Submission byway of reply to Taronga Mines submission.

Taronga Mines Pty Ltd Application and Submission.

Taronga Mine.

Figure 2 Locations of air quality and meteorological monitoring

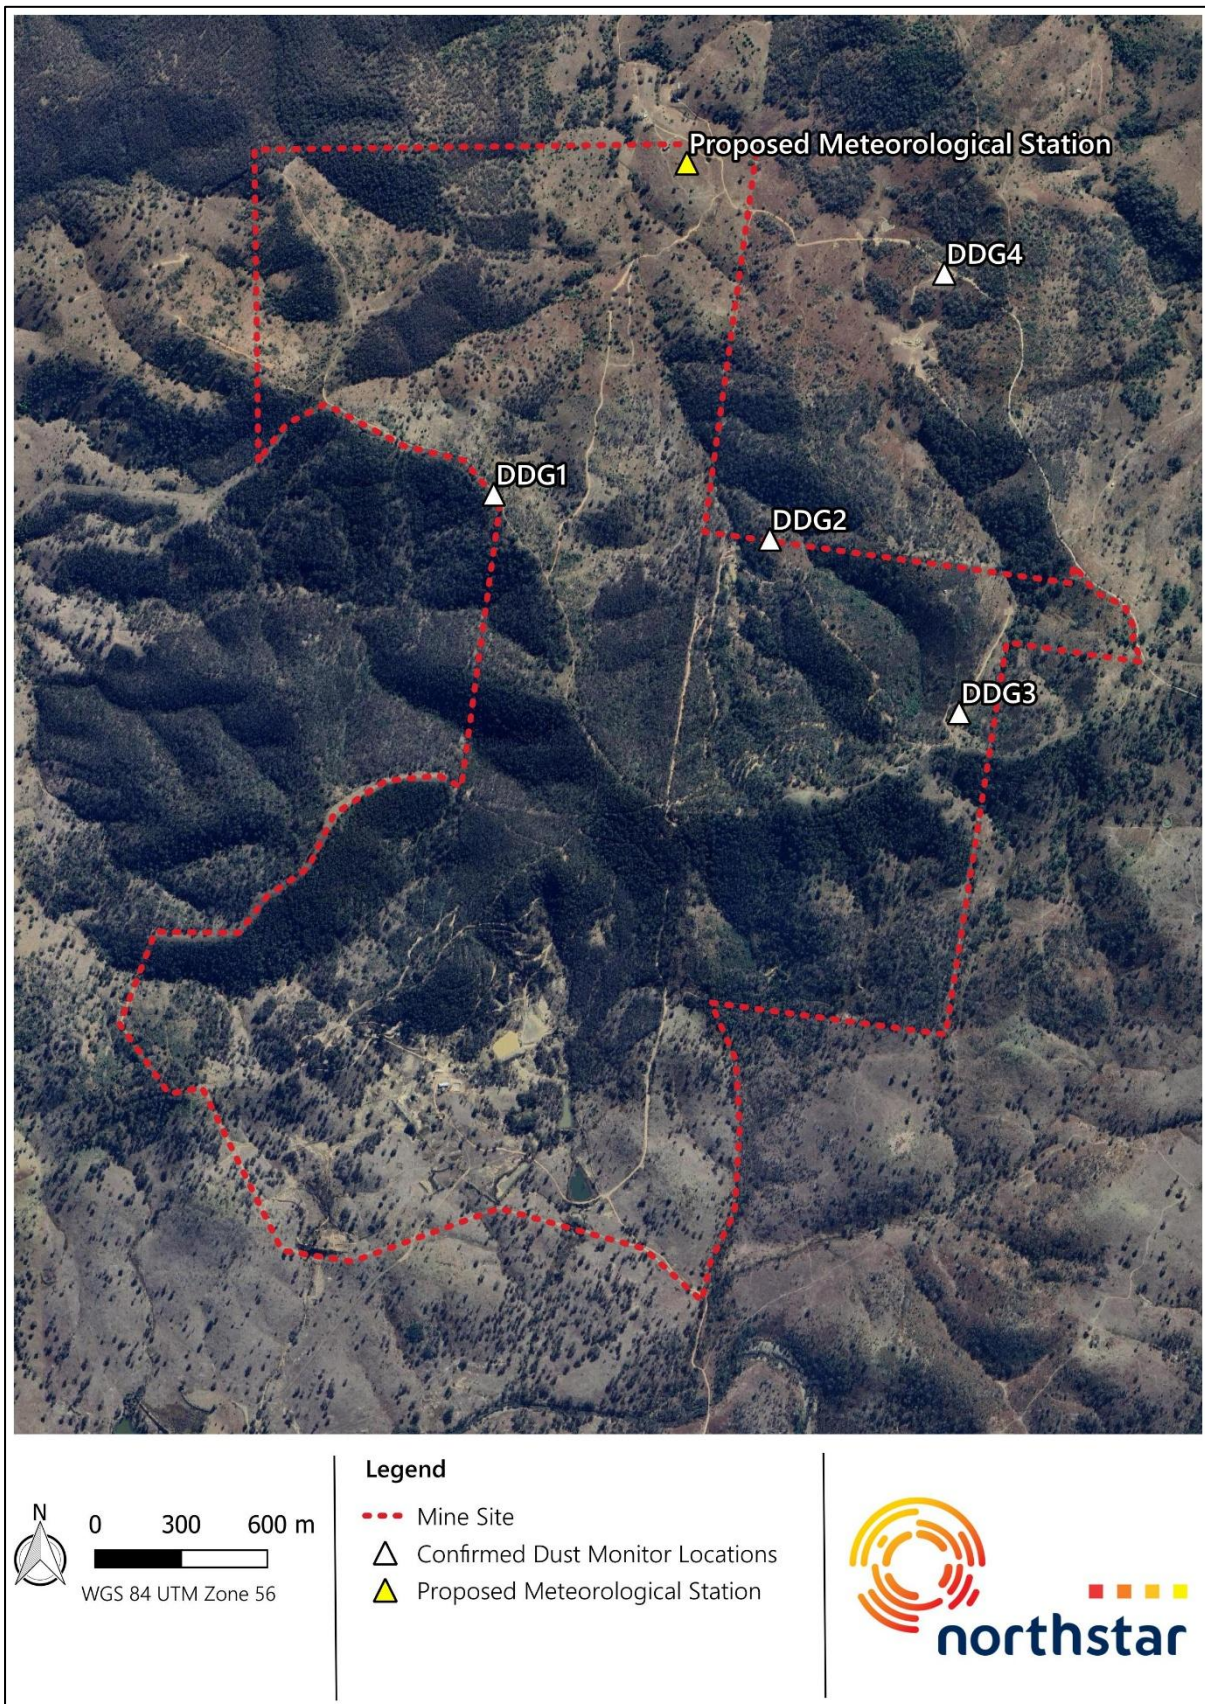
j) Taronga Mine Site has no onsite measured meteorological data despite Taronga Mines Pty Ltd having the site for ~4 years and knowing that accurate meteorological data is essential for the preparation of an Air Quality Impact Assessment. The author of the Northstar Air Quality Impact Assessment uses CALMET computer modelling to generate wind directions and flows for the Taronga Mine Site and asserts this gives accurate wind directions and flows for Taronga Mine Site. However, nowhere in Northstar's Air Quality Impact Assessment is there any representation of Taronga Mine Site and surrounding area localised wind flows. Because of the complex topography and its' effects on local wind surrounding Taronga Mine Site there is no substitute for actual Taronga Mine Site and surrounding area wind data.

l) Taronga Mines Pty Ltd has been negligent in not establishing a meteorological recording site at their Taronga Mine Site and surrounding area. The people of Emmaville and surrounding area deserve better and should not be hostage to contentious meteorological data for the purpose of a contentious Air Quality Impact Assessment for Taronga Mines Pty Ltd Mining Permit Application.

e) Taronga Mines Pty Ltd uses contentious wind and meteorological data in their Mining Permit Application for their Taronga Mine Site. Taronga Mines Pty Ltd have owned the Taronga Mine Site since since 7th November 2021, ie nearly 4 years and in that time have failed to install any meteorological data recording system appropriate for the topography of the Mine Site and surrounding area.

f) Taronga Mines Pty Ltd must be required to undertake and produced actual, accurate recorded wind and meteorological data for Taronga Mine Site and Emmaville before any issue of any Mining Permit.

Figure 16 Updated 99.9th percentile 1-hour arsenic concentration predictions

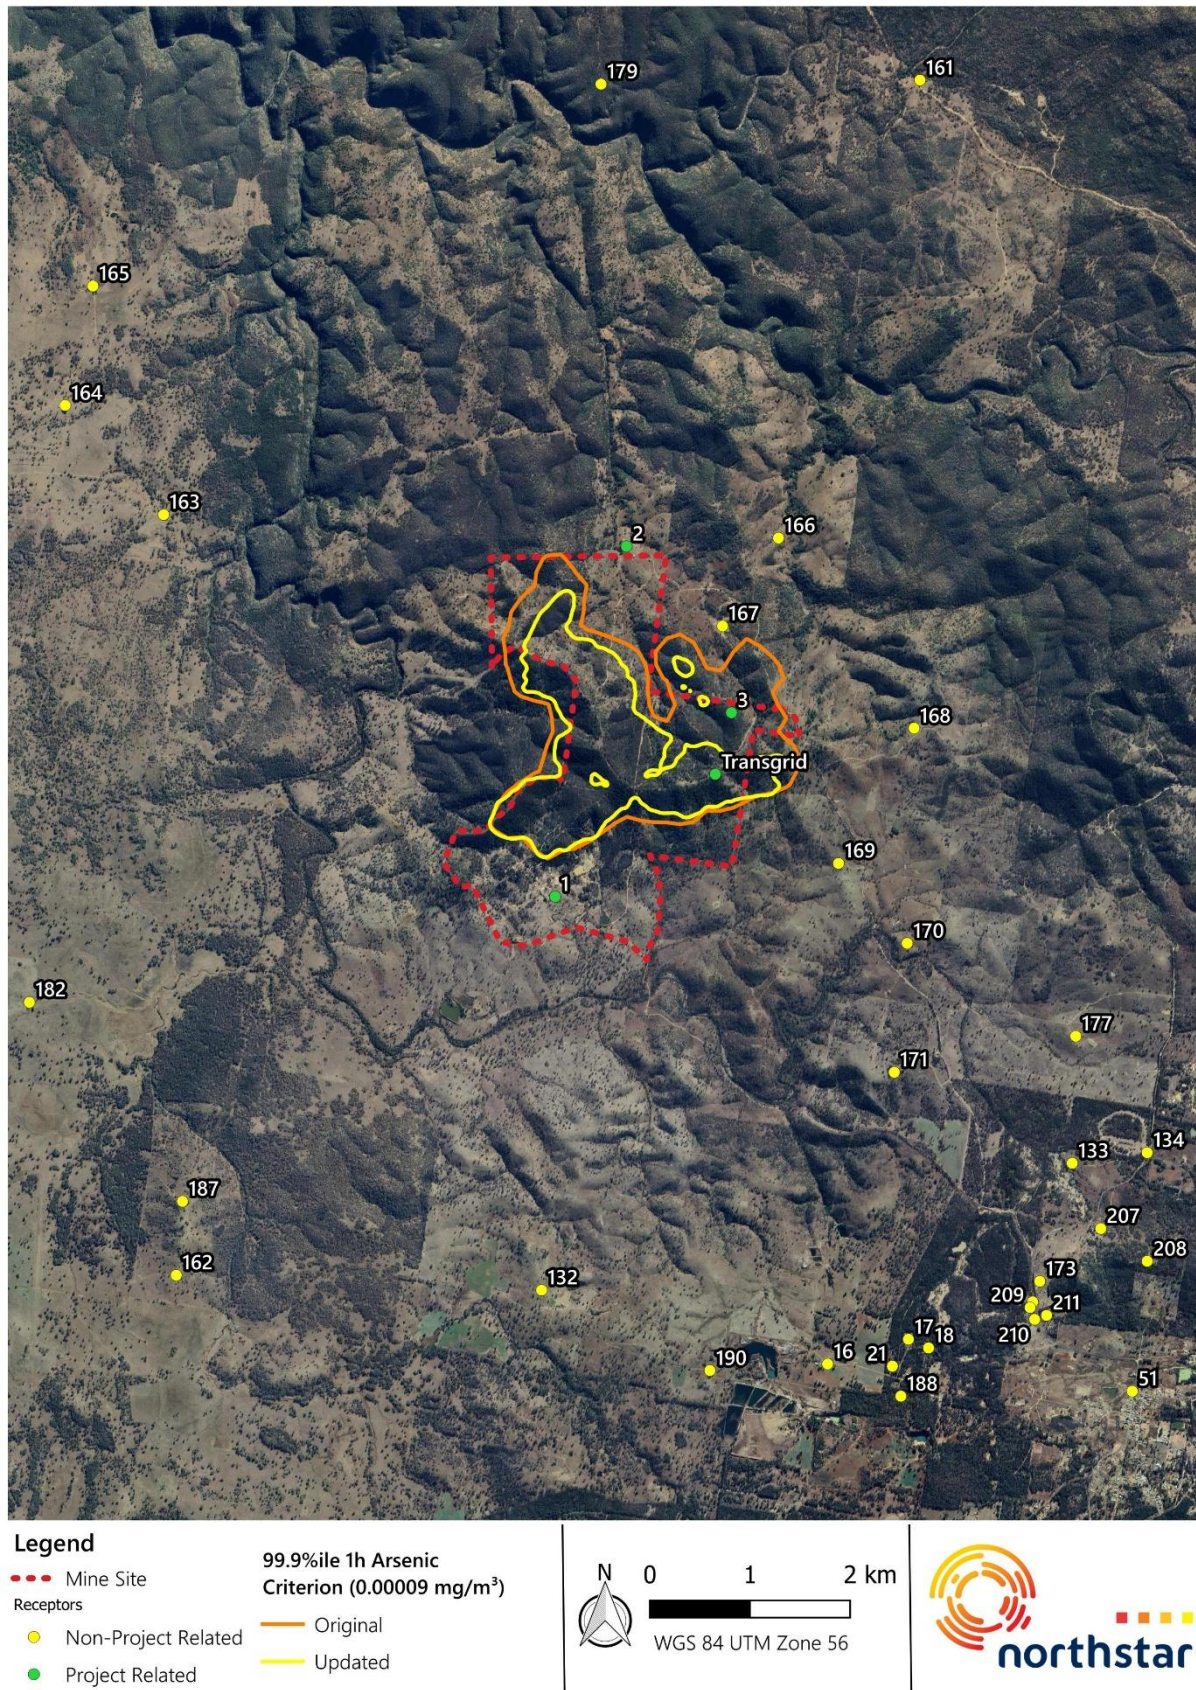
- c) Figures 11 through 22, pages 64 through 116 of the Northstar Air Quality Impact Assessment show an aerial view of the Taronga Mine Site and some surrounding area overlaid with isobar contour lines of dust PM10, PM2.5, and arsenic concentrations.

- d) there are 12 presentations modelled representing dust and arsenic concentrations. The isobar contours are, apart from size, remarkably similar and remarkably symmetrical around the Taronga Mine Site. Obviously the dust and arsenic concentrations are shown for the zero wind condition as with any wind there would be no dust upwind of the emission site, ie Taronga Mine Site, and a tail of dust extending downwind from the emission site. The legends of figs 11-22 have no mention of the wind condition assumed for the model. The Northstar Air Quality Assessment Report Section 5.1 Dispersion Modelling and Section 5.2 Modelling Scenarios make no mention of any wind condition assumed for the modelling, the only conclusion possible is the modelling must be for the zero wind condition.

- f) in the absence of data otherwise, it must be taken that Taronga Mine Site dust cloud travels in the direction of Emmaville for something like half the year.
